The Old Workhouse - App Ref: 8378/APP/2020/337

In the context of the Non-Material Amendment application (reference 8378/APP/2020/1448) and the new Listed Building Consent application (reference 8378/APP/2020/1486), it would be useful to pick up on one outstanding matter for the details of condition application (reference 8378/APP/2020/337).

PROPOSED REAR ELEVATION

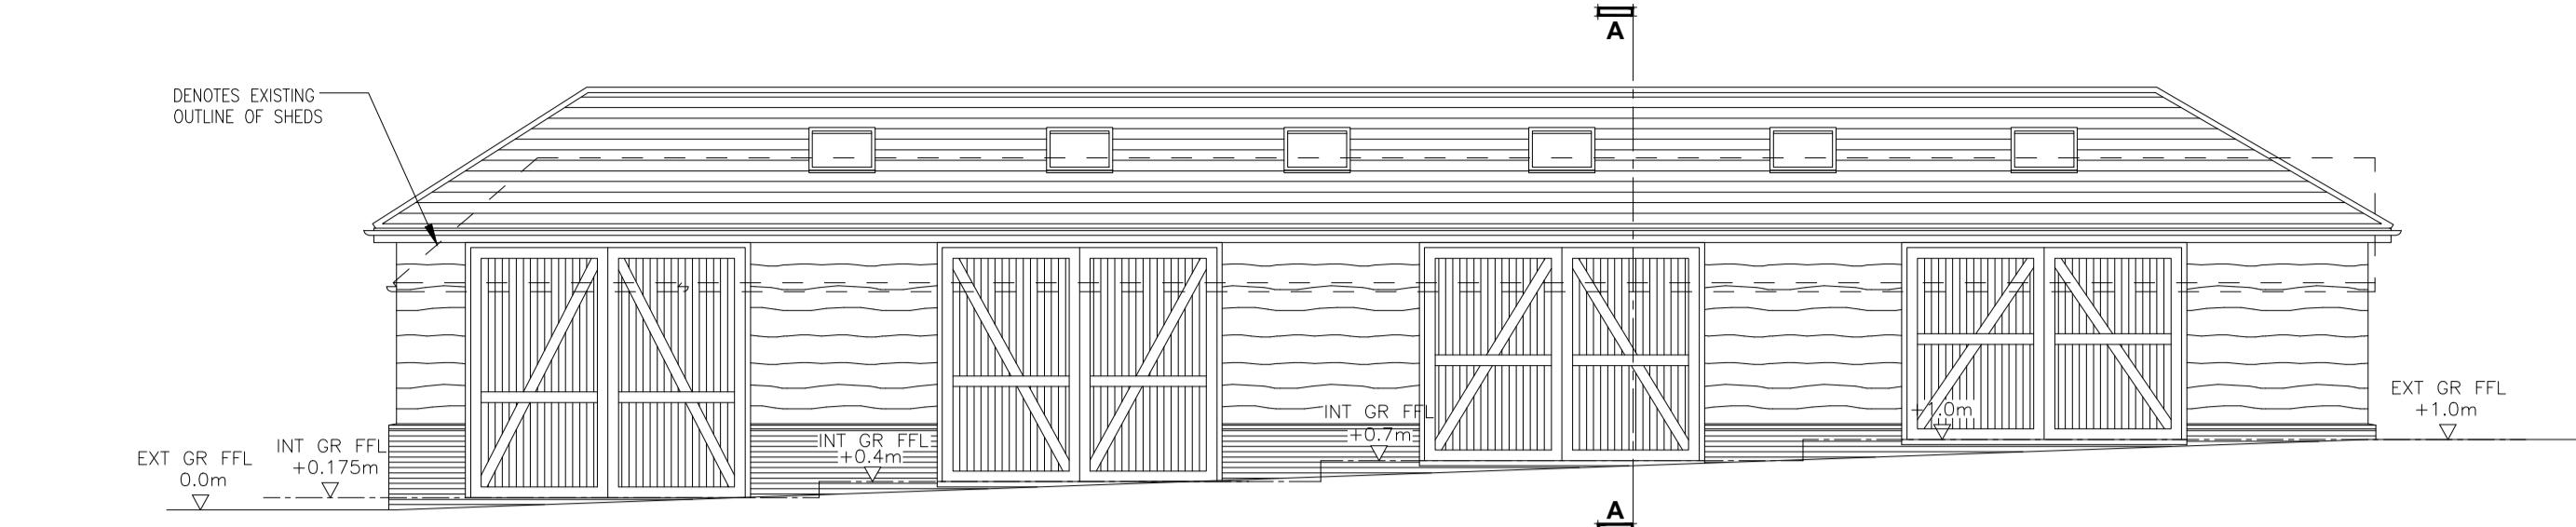
In addition to the specification submitted for the rooflights, could you submit a specification for the proposed windows on the rear elevation?

The images on application show the general doors and windows in wood stained black with Cuprinol black ash stain as per the sample viewed on site by the conservation officer Alisha.

Generally I would say use standard casements by Mumford & Wood and doors from a similar range see attachments.

Their casements are all Siberian oak with sapele sill units.

All would be double glazed 24mm units as standard and stained black ash.
